KIRKLEES METROPOLITAN COUNCIL INVESTMENT & REGENERATION SERVICE

DELEGATED DECISION TO DETERMINE APPLICATIONS FOR LISTED BUILDING CONSENT

Reference No:	2025/65/90399/W
Site Address:	202, Blacker Road, Edgerton, Huddersfield, HD2 2AA
Description:	Listed Building Consent for internal alterations, installation of roof lights, boundary works and gated access, and removal of external store (within a Conservation Area).
Recommending Officer:	Edward Cheseldine

Officer Report - Listed Building Consent

Status:	Planning
Date:	Jan 2025
Scale:	1:100
Drg No:	BR07.#

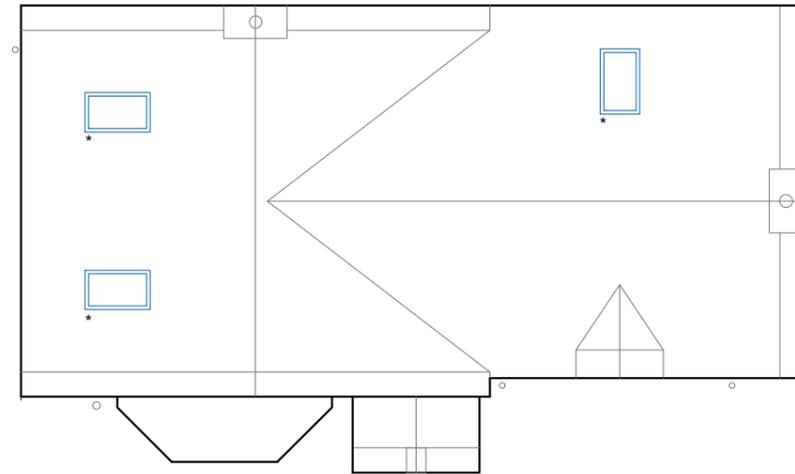
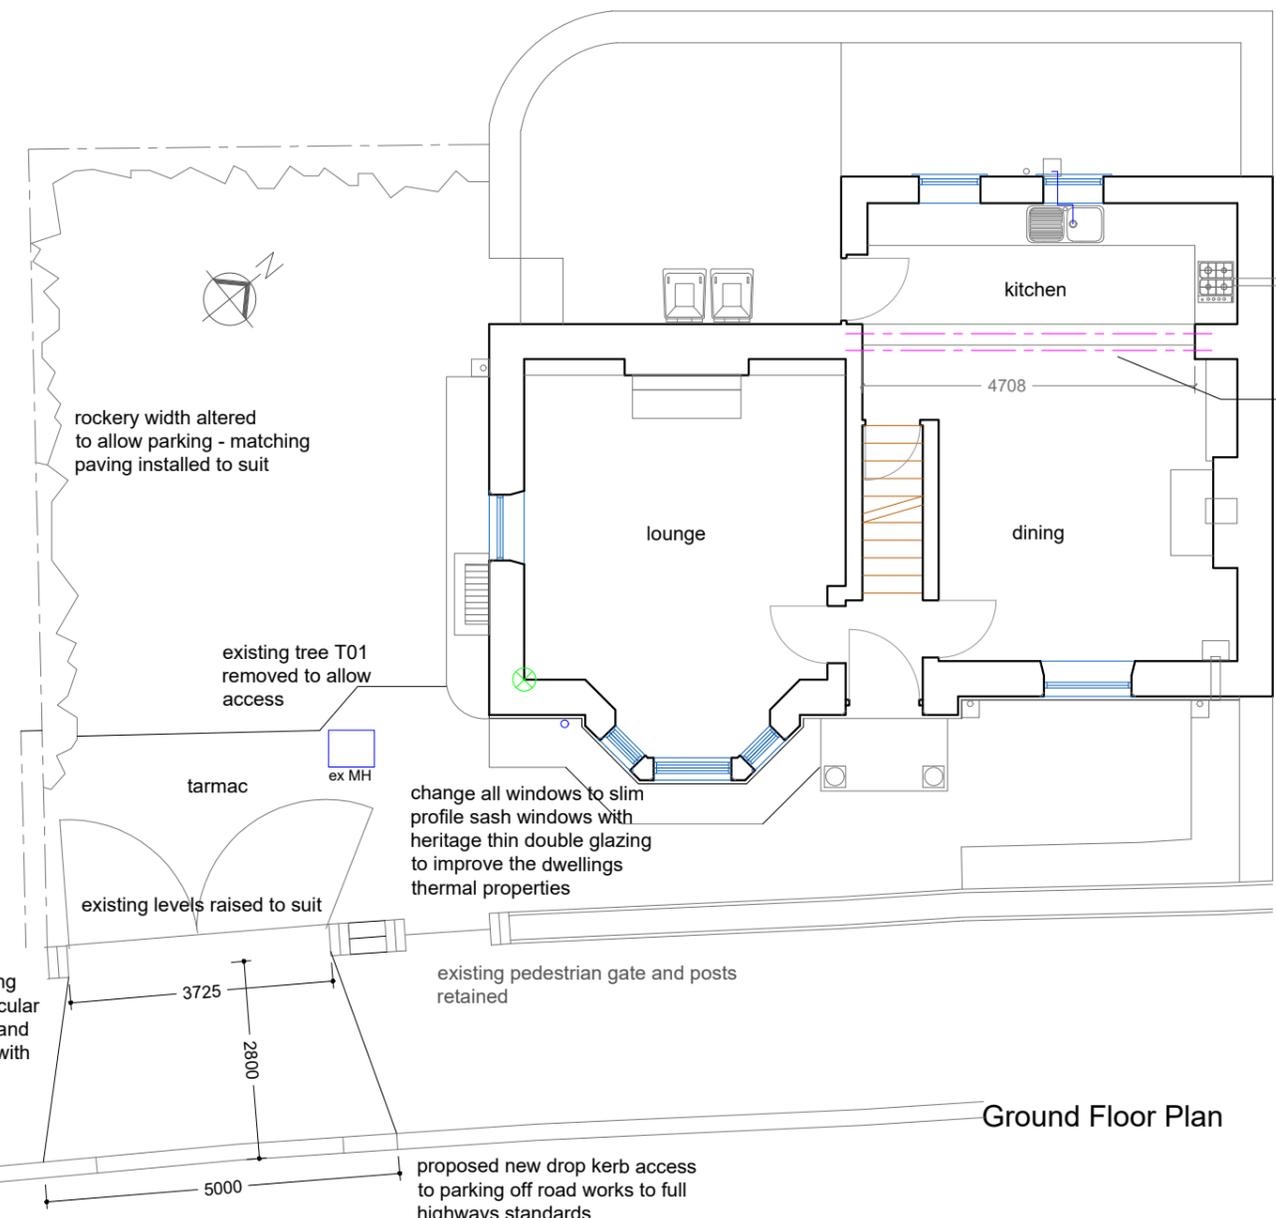
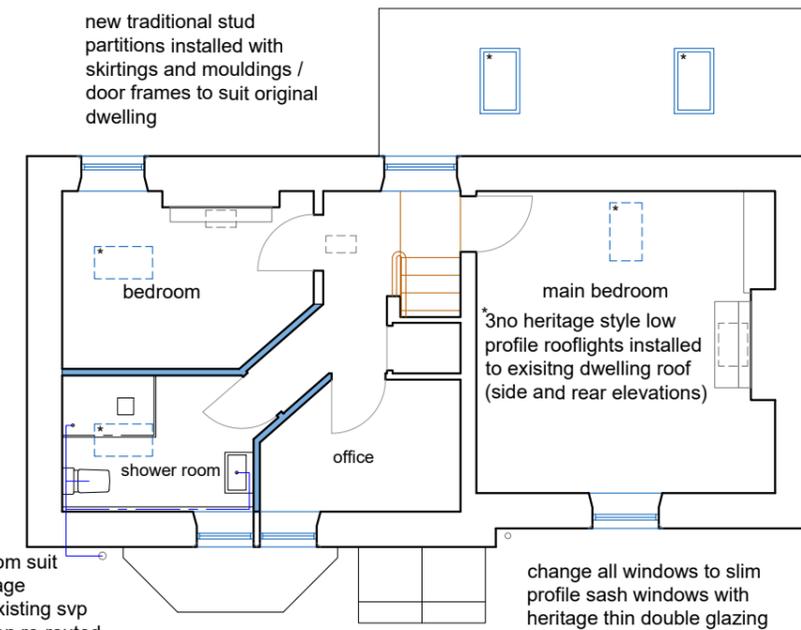
The applicant was asked to reduce the number of skylights on the side elevation to one window. The applicant was asked to reduce the number of skylights on the side elevation to one window. Amended plans were received to include reducing the number of side elevation skylights

KC Conservation & Design – No objection, subject to the removal of one side windows and conditions for materials.

Amended plans were received reducing the number of skylights on the side elevation. This is satisfied the requirements of Conservation & Design.
